Single storey side extension linking semi-detached garage to existing house including conversion of existing garage to habitable use and rear extension. This application affects the setting of a listed building.

Hazel Cottage Church Lane Yapton

Thank you for your internet representation made on 22nd February 2019 which has been recorded as '**an objection**' with the comments as follows:

PROJECT TITLE Proposed Development at Hazel Cottage Church Lane Yapton Arundel	DRAWING TITLE Proposed Elevations		No	REVISION	DATE
	STATUS Planning Application				
	SCALE 1:100 @ A3	DATE 03.01.2019			
	DRAWN BY DE	DRAWING NO PA-302-06

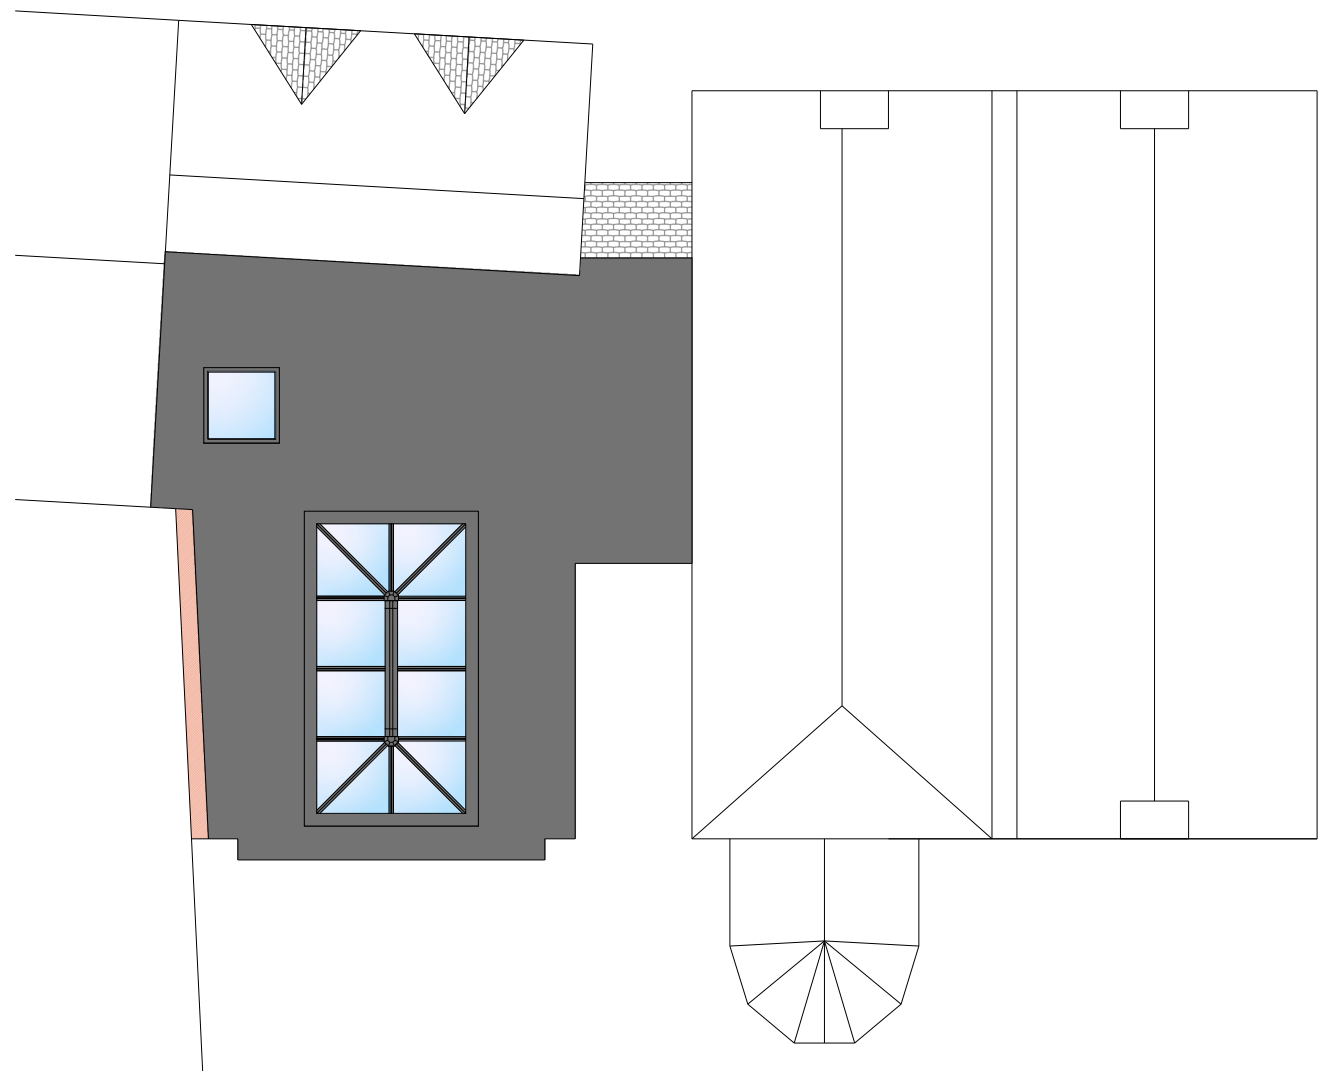
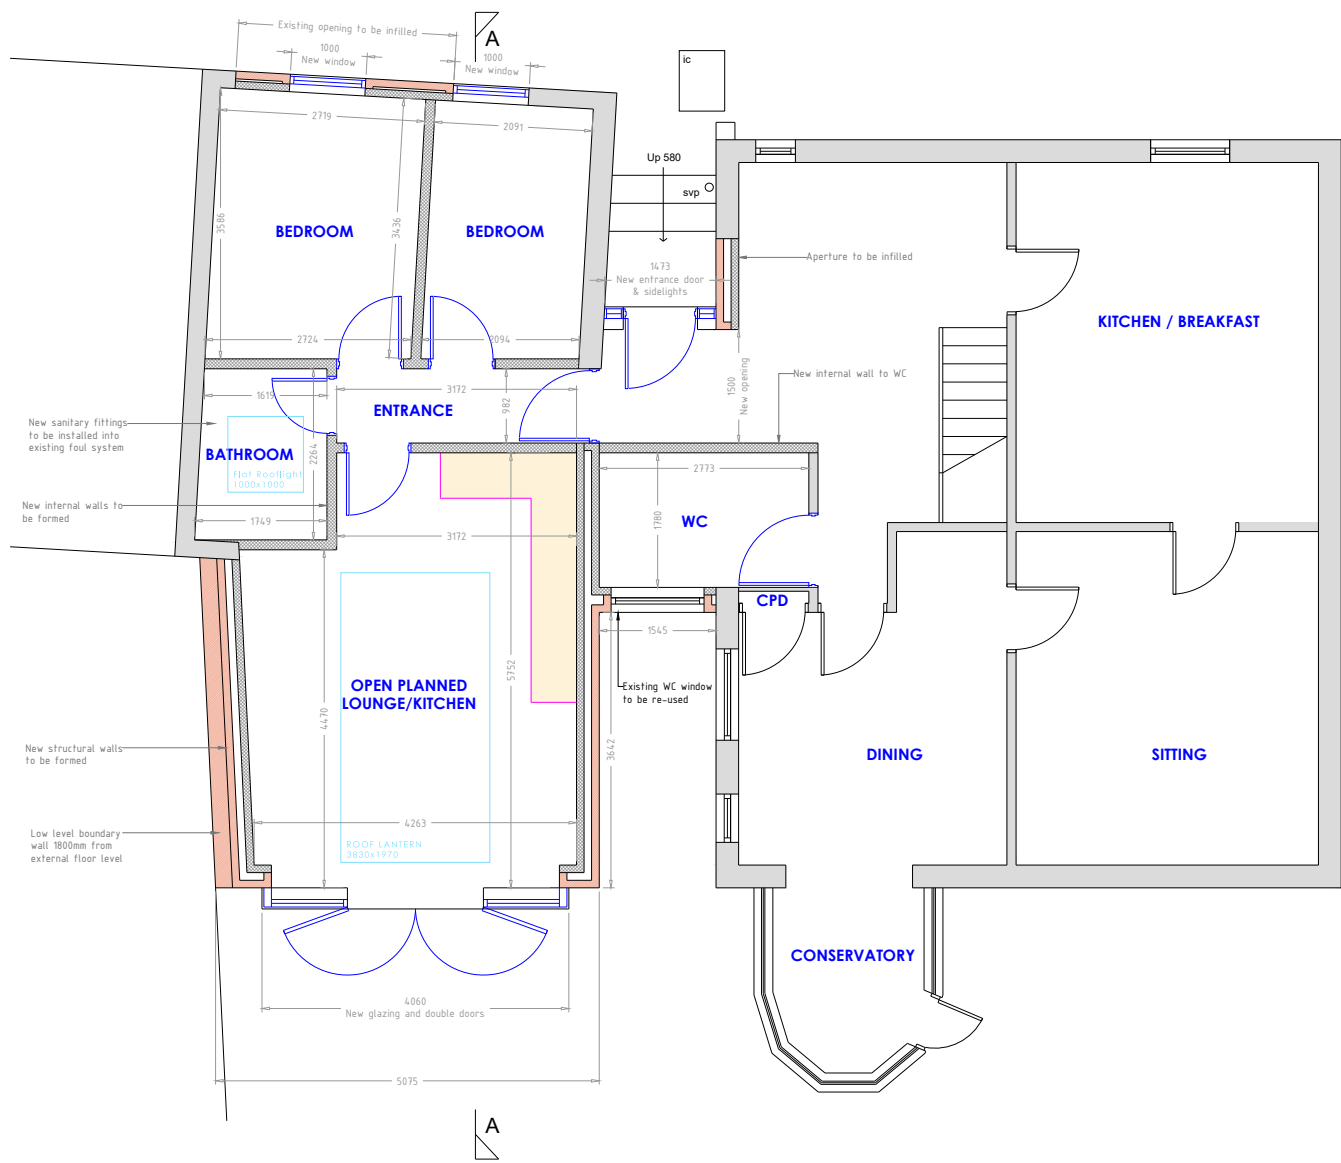
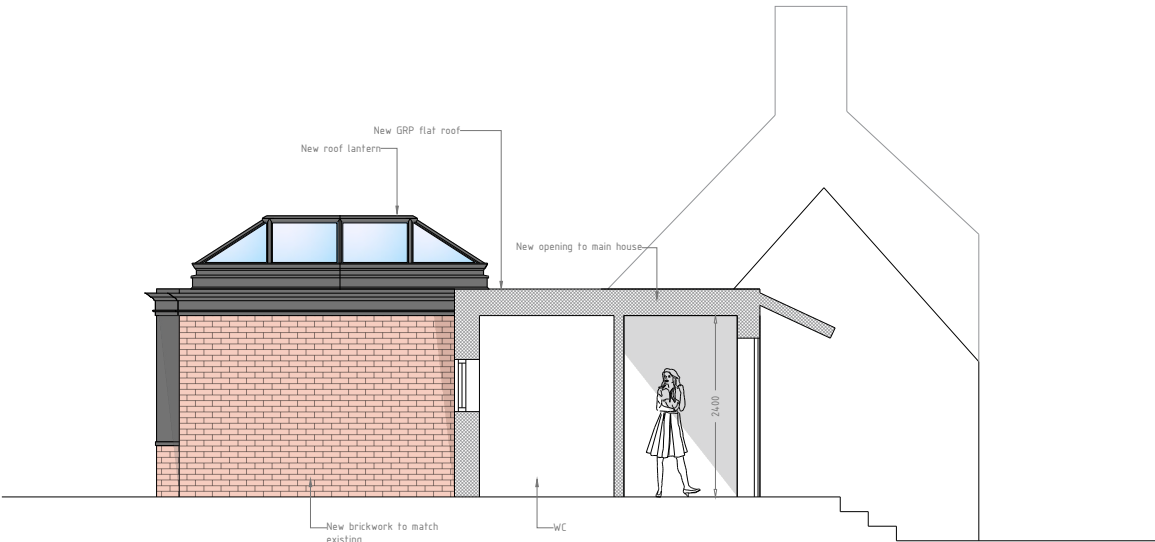
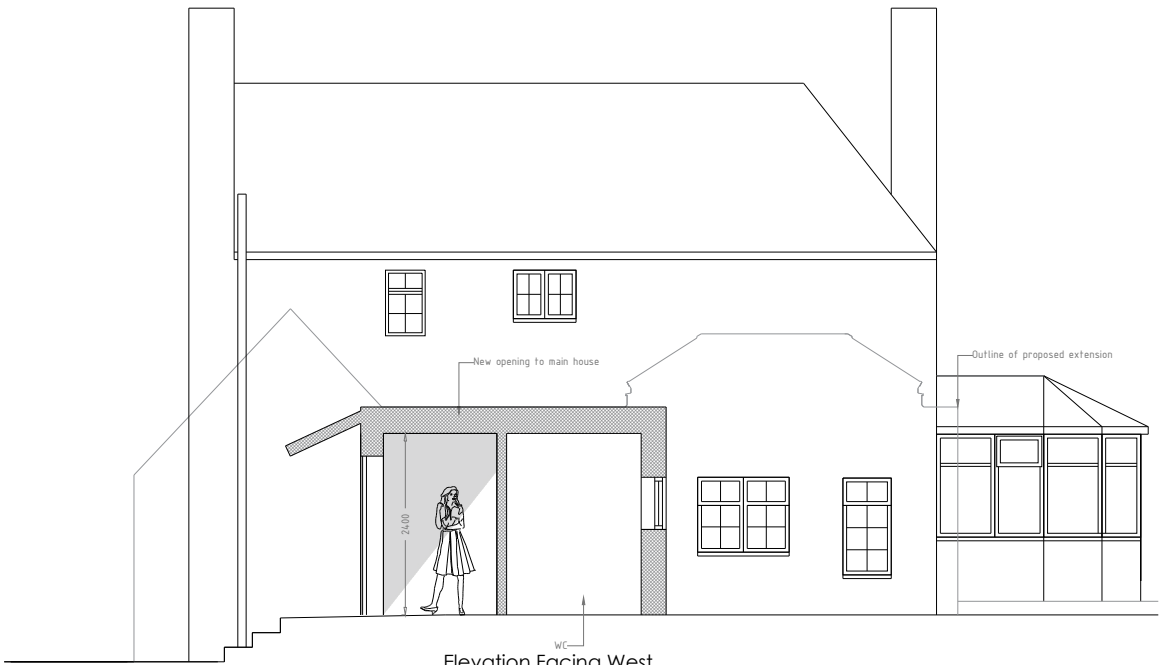
I note the windows to be added to the front matching in design, is this to match Twelfth of Never (wood sash) or UPVC that match the new windows replaced in Hazel cottage?

I have grave concerns regarding the excavation of the ground needed for foundations, drainage, sewers etc and the potential risk to my property of movement and/ or damage, also the risk of fire with the thatched roof, the dormer windows to the front seem they would be very close to the thatch roof. I also need access from time to time for maintenance work.
